Deadline 9 Submission

This note represents a Deadline 9 submission, with detailed comment limited to aspects of Issue Specific Hearings, ISH2, ISH11, ISH12 and ISH 13.

Issue Specific Hearing 2 (ISH2) Onshore siting, design and construction

Issue Specific Hearing 12 (ISH 12) - Noise

Plate A25.5.1 Indicative Onshore Substation Layout – HVAC

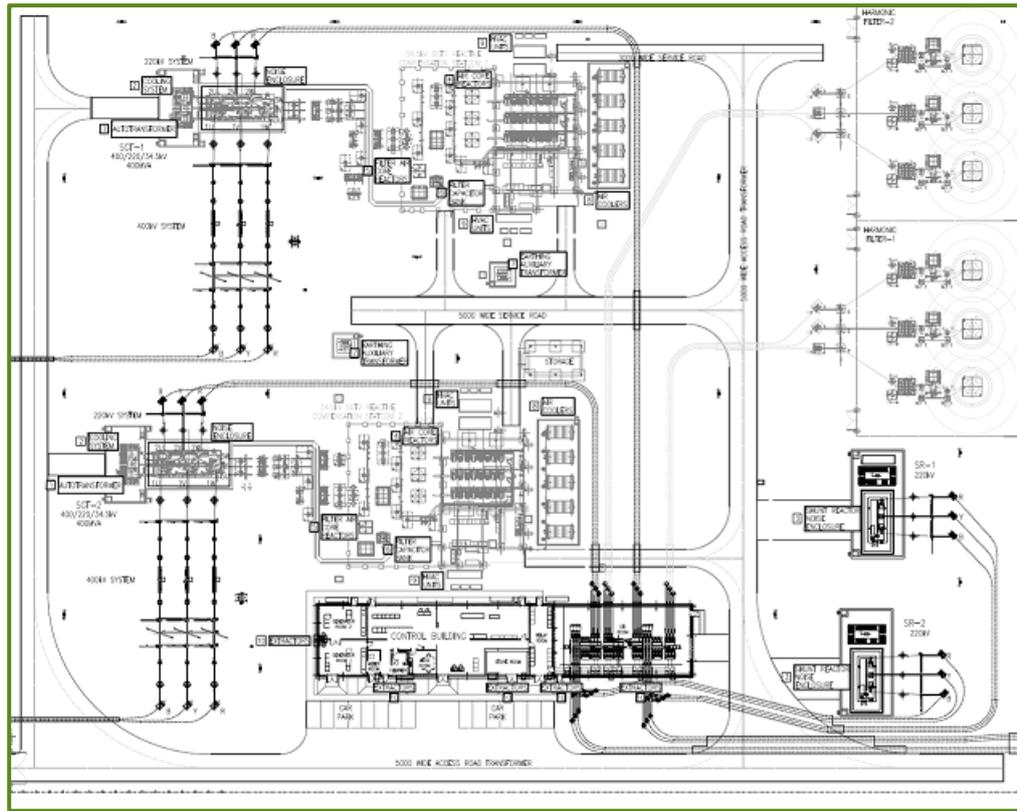
ISH2 failed to elicit a satisfactory explanation of why the National Grid substation appears to be far larger than that needed just to effect connexion of EA1N and EA2 to the Overhead Transmission Lines. The reasons put forward by the Applicant and supported by National Grid as to why the NG substation was not the subject of a separate DCO remain unconvincing and have re-enforced the widely held view that the substation will be used as the connexion point for trans-North Sea interconnectors, programmes to be managed by another part of the National Grid enterprise.

Plate A25.5.2 Predicted Noise Levels East Anglia ONE North

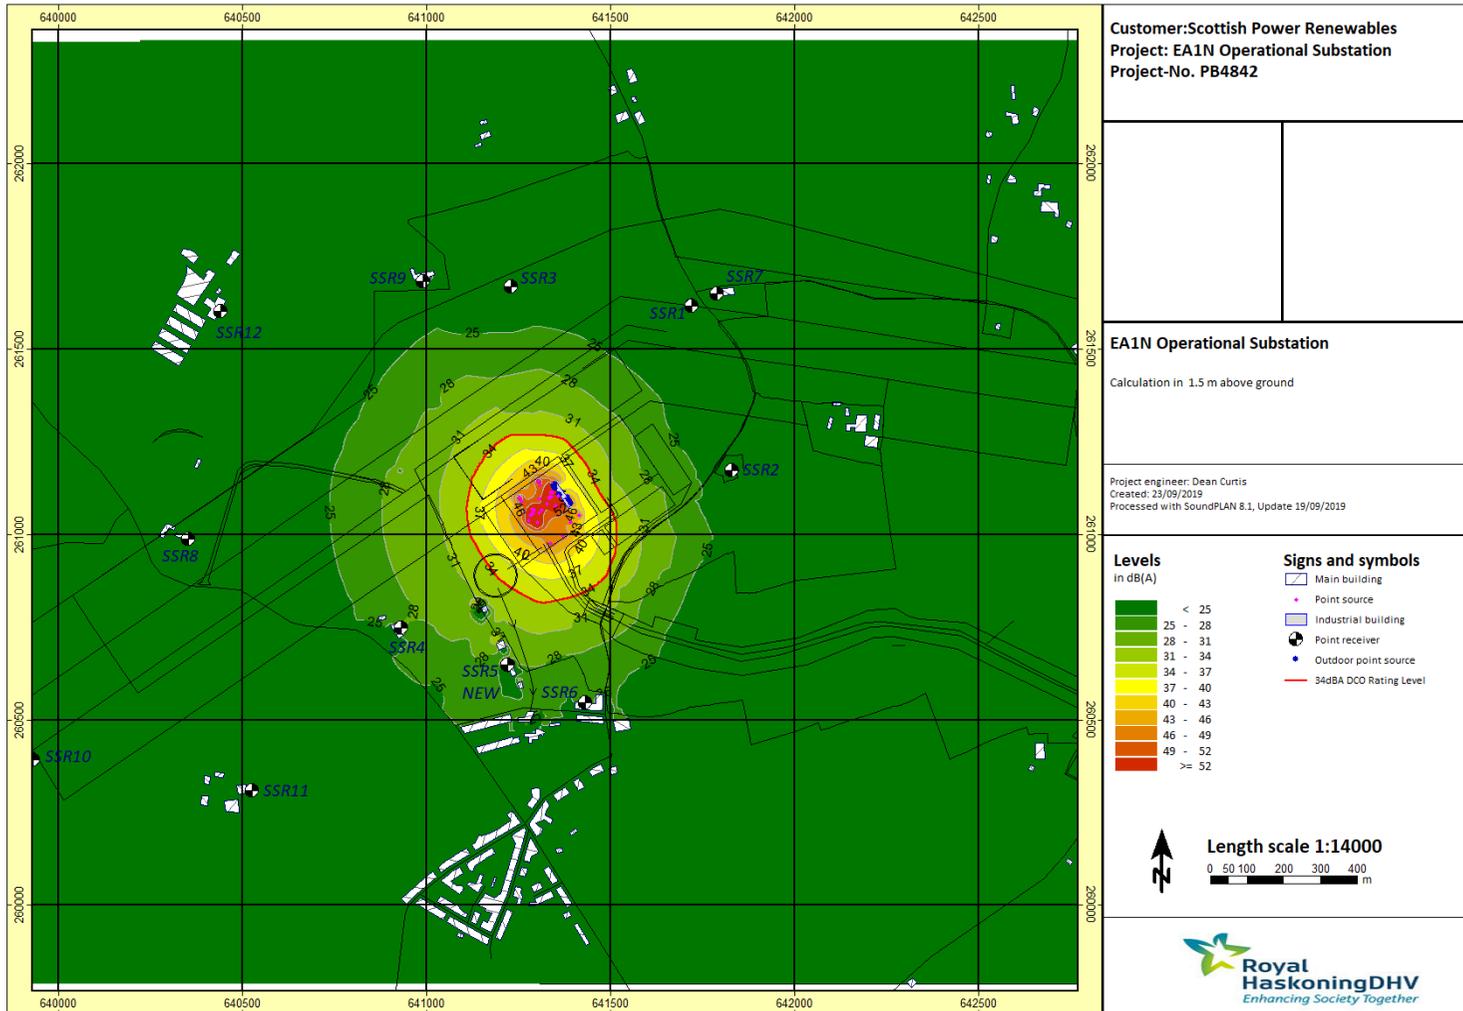
ISH 12 was disappointing on the subject of substation Operational Noise, and it was clear from the start that experts from both ESC and SASES disagreed with noise analysis presented by the Applicant’s subject matter expert. For those observers lacking understanding of the nature of sound generated by High Power transformers and the true nature of sound propagation, it must have seemed like a disputation on **“How many angels can dance on the head of a pin?”** Given the risk that acceptance of the DCO Application as it currently stands, could well impose a permanent industrial soundscape upon a quiet rural environment, I feel that the Examination Panel would have benefitted enormously from having an Examiner with some in-depth comprehension of the subject matter being discussed. Some experience in the application of Statistical Methods would also appear to have been an advantage.

From the above it can be seen that the noise spectrum of a high power transformer is dominated by multiples of the First Harmonic (100 Hz), showing distinct lines at 100Hz, 200Hz, 300 Hz, etc. The Applicant's portrayal of acoustic signature is in part flawed, because the Applicant has adhered rigidly to the "standard" spectrum set out in BS 4142, ie 63Hz, 125 Hz, 250 Hz, 500 Hz, 1 kHz, 2 kHz, 4 kHz and 8 kHz, which would be appropriate if the noise signature in question originated in a highly de-correlated source like motorway traffic.

During ISH12, the Applicant sought to convince the Examining panel that recent acoustic measurements in the environs of Bramfield and attributed to an EA1 survey, were sufficient to show that concerns regarding the potential operational noise at Friston were unfounded. Adopting a similar *post facto* approach for Friston is most unwise, in that there are many differences between the two sites and once installed and shown to exceed pre-set limits, it will be very difficult to arrange an 'outage' to carry out remedial work. The Applicant must, as a matter of completeness supply the ExA with:

- Source spectra for the dominant emitters to be sited at Friston.
- A full list of the input parameters used by the selected sound propagation model.
- A full spectral analysis of the background noise level in the vicinity of the three designated receptors at Friston and which can act as the "gold" standard against which actual substation noise can be assessed.
